# CITY OF ALBUQUERQUE

May 22, 2023

**Re: 9909 Indian School**  
**9906 Indian School Rd. NE**  
**Traffic Circulation Layout**  
Engineer's/Architect's Stamp XX-XX-XX (J20-D041)

Based upon the information provided in your submittal received 05-05-23, the above referenced plan cannot be approved for Building Permit until the following comments are addressed:

AS101

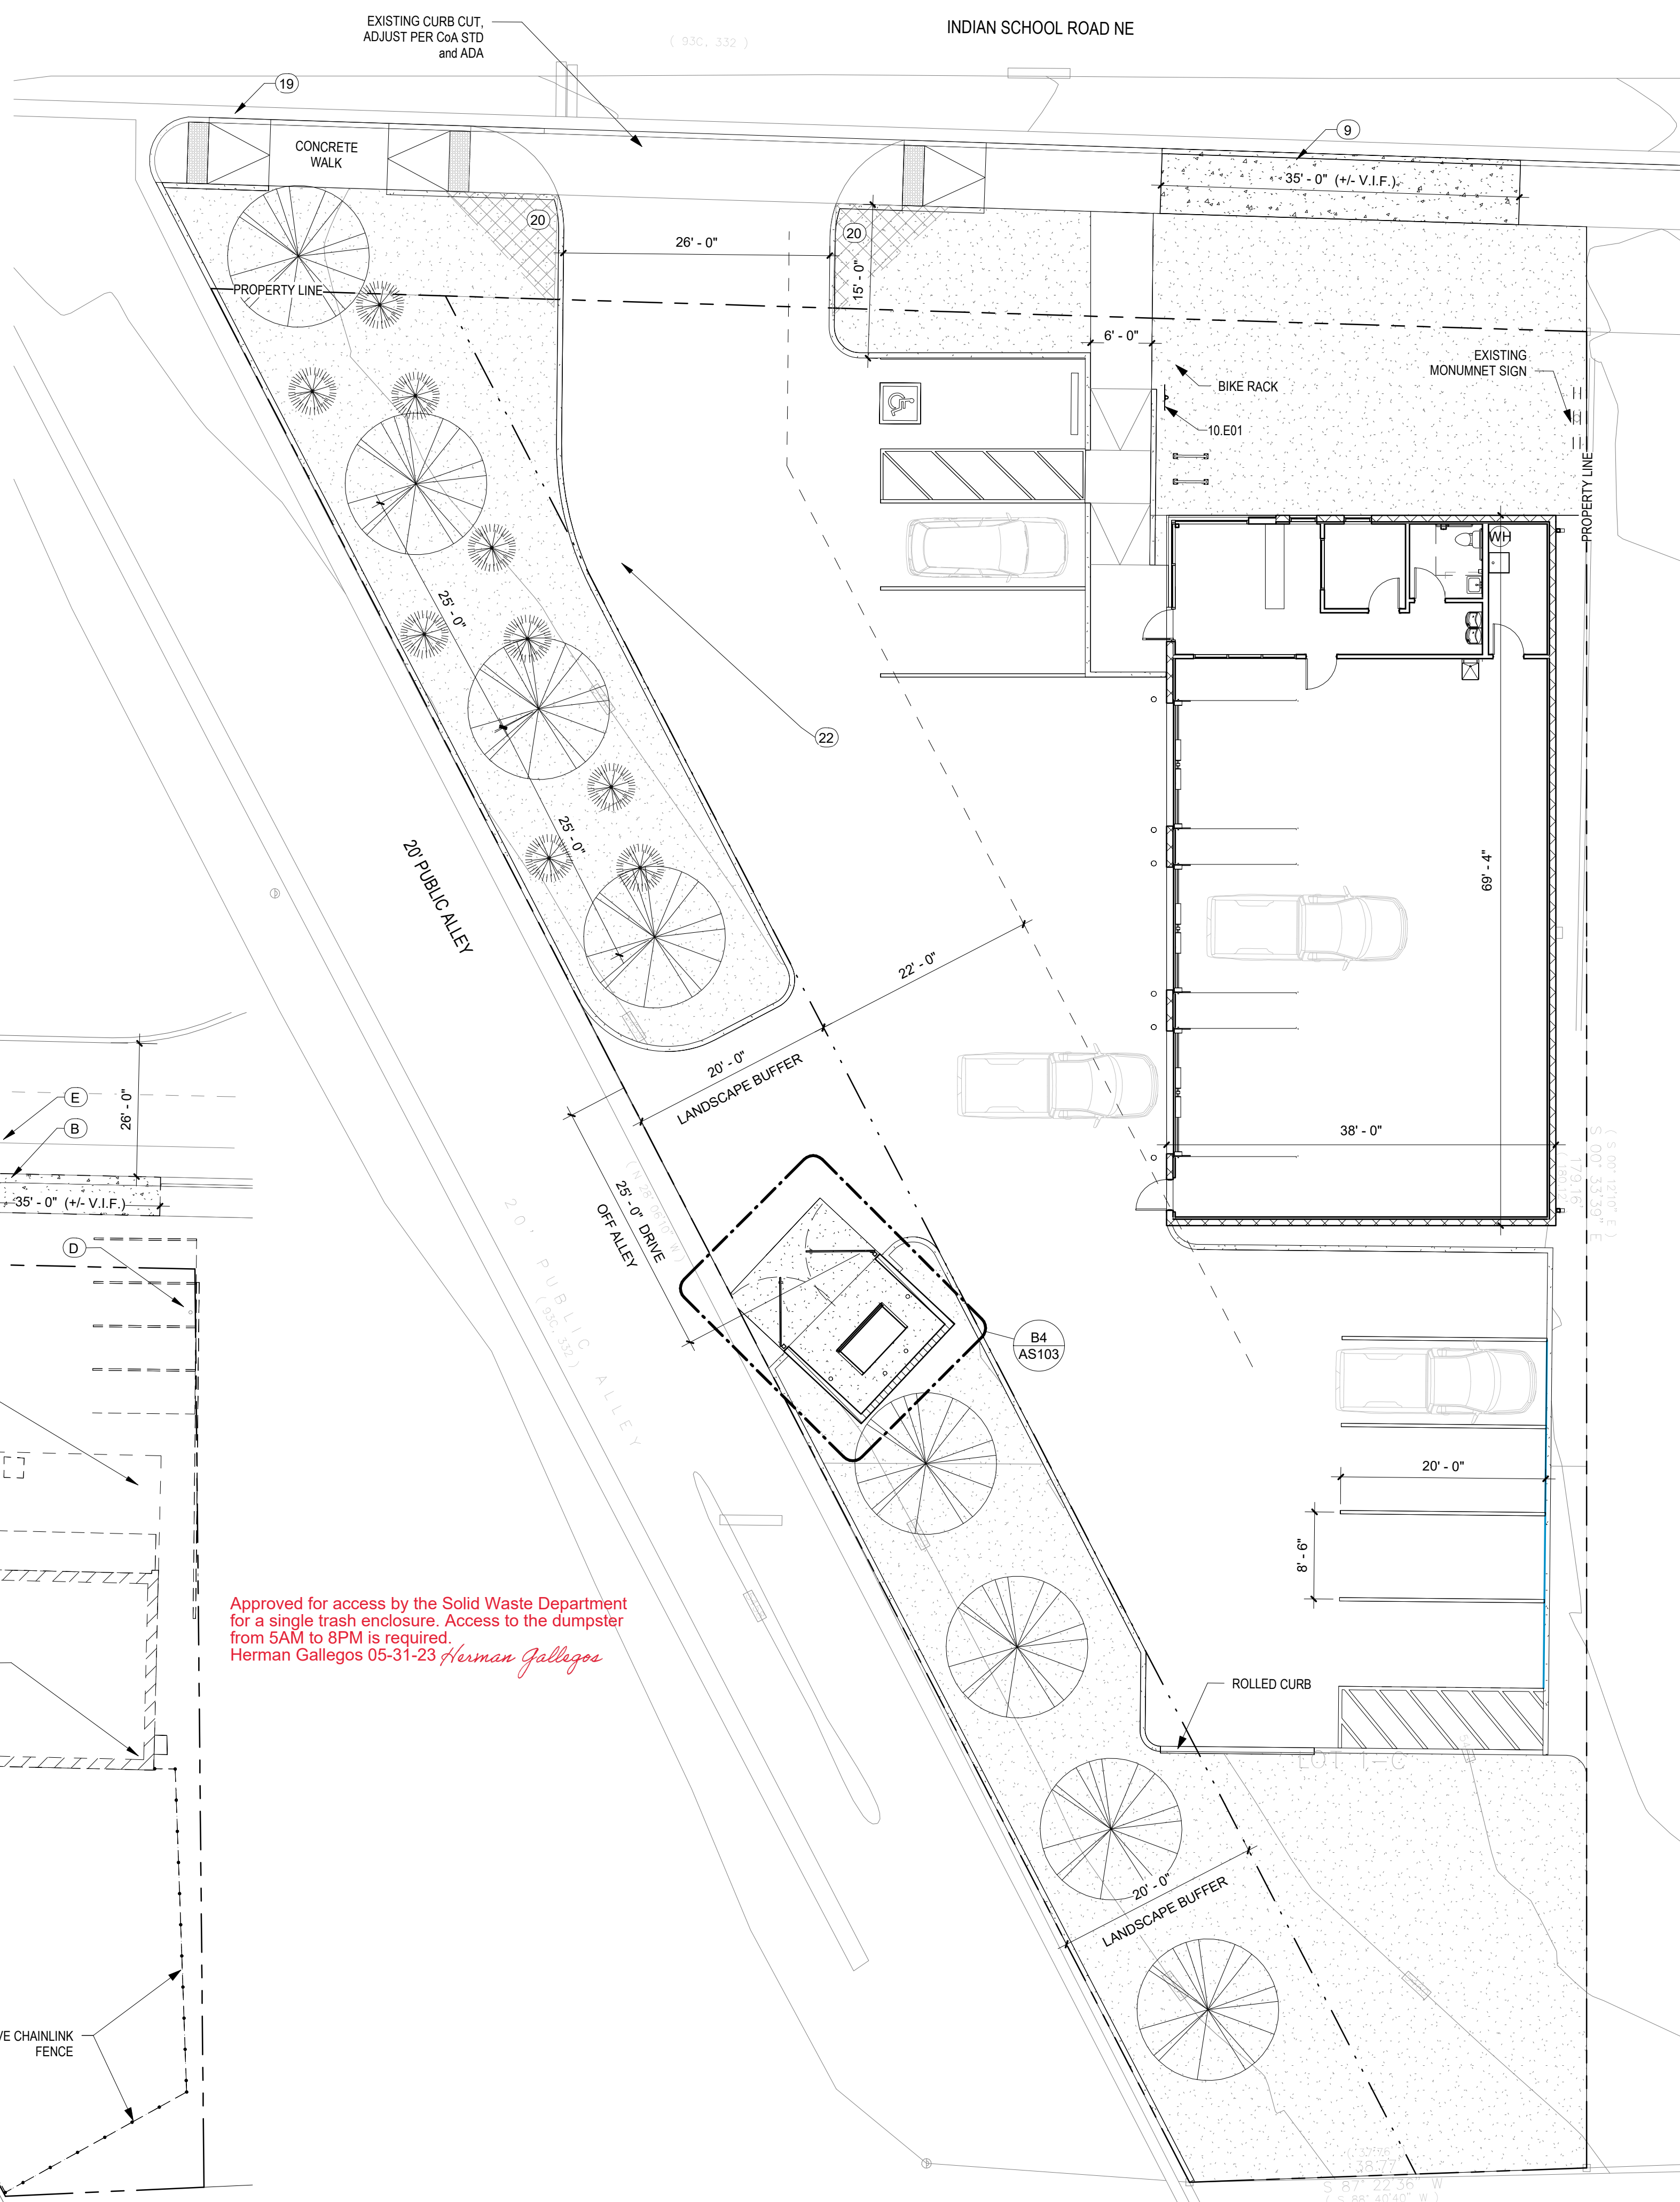
1. Please show a vicinity map showing the location of the development in relation to streets and well-known landmarks.
2. List the number of Motorcycle and Bicycle parking spaces required by the IDO.
3. Identify all existing access easements and rights of way width dimensions.
4. Identify the right of way width, medians, curb cuts, and street widths on Indian School Rd.
5. Please provide site access's design details, and reference COA std dwg.
6. Please list the width and length for all existing and proposed parking spaces. Some dimensions are not shown.
7. The minimum parking stall dimensions are:

8. The ADA accessible spaces must include an access aisle. Van accessible aisles should be 8ft wide; all others should be 5ft wide.
9. The ADA accessible parking sign must have the required language per 66-7-352.4C NMSA 1978 **"Violators Are Subject to a Fine and/or Towing."** Please call out detail and location of signs.
10. The ADA access aisles shall have the words **"NO PARKING"** in capital letters, each of which shall be at least one foot high and at least two inches wide, placed at the rear of

11. ADA curb ramp at the corner of Indian School and the Public Alley must be updated to current standards and have truncated domes installed.
12. Provide a copy of Solid Waste and Fire Marshal approval.

13. Motorcycle parking spaces shall be designated by its own conspicuously posted upright sign, either free-standing or wall mounted per the zoning code.

14. The pavement marking "MC" should be shown in the opposite direction for motorcycles entering the parking space.
15. All bicycle racks shall be designed according to the following guidelines:

16. Bicycle racks shall be sturdy and anchored to a concrete pad.
17. A 1-foot clear zone around the bicycle parking stall shall be provided.
18. Bicycle parking spaces shall be at least 6 feet long and 2 feet wide.

19. The minimum drive aisle width for two-way traffic is 22 ft.

20. Show the Intersection clear sight triangle and add the following note to the plan:  
"Landscaping and signage will not interfere with clear sight requirements. Therefore, signs, walls, trees, and shrubbery between 3 and 8 feet tall (as measured from the gutter pan) will not be acceptable in the clear sight triangle."
21. Please specify the City Standard Drawing Number when applicable.

22. Unused curb cuts must be replaced with sidewalk and curb & gutter. A build note must be provided referring to the appropriate City Standard drawing.
23. Add a note stating "All broken or cracked sidewalk must be replaced with sidewalk and curb & gutter." A build note must be provided referring to the appropriate City Standard drawing.
24. Please provide a letter of response for all comments given.
25. Traffic Studies: See the Traffic Impact Study (TIS) thresholds. In general, a minimum combination of 100 vehicles entering and exiting in the peak hour warrants a Traffic Impact Study. Visit with Traffic Engineer for determination, and fill out a TIS Form that states whether one is warranted. In some cases, a trip generation may be requested for determination (**Contact Matt Grush: [mgrush@cabq.gov](mailto:mgrush@cabq.gov)**).

D3 BICYCLE RACK DETAIL
1/2" = 1'-0"

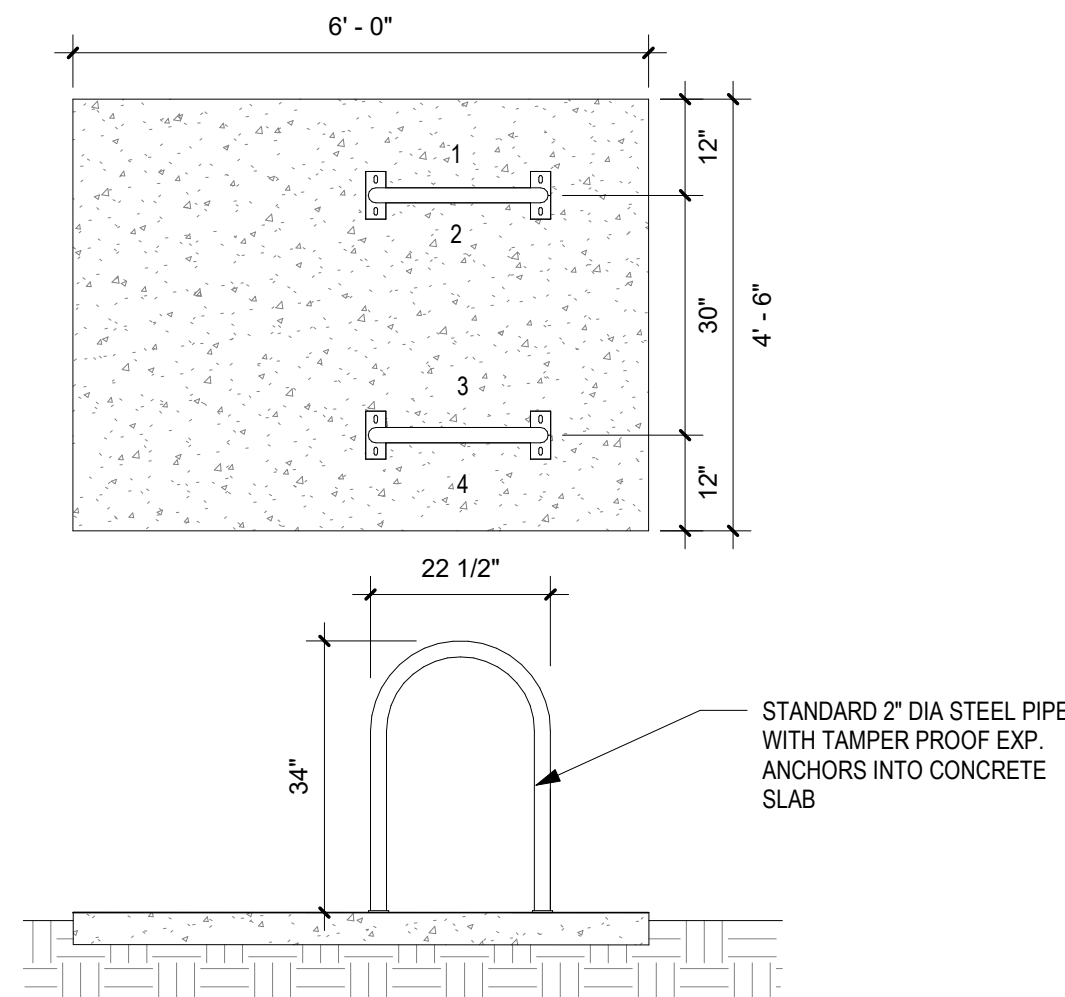
- a. The rack shall be a minimum 30 inches tall and 18 inches wide.
  - b. The bicycle frame shall be supported horizontally at two or more places. Comb/toaster racks are not allowed.

- c. The rack shall be designed to support the bicycle in an upright position. See the IDO for additional information.
  - d. The rack allows varying bicycle frame sizes and styles to be attached.

- e. The user is not required to lift the bicycle onto the bicycle rack.
  - f. Each bicycle parking space is accessible without moving another bicycle.
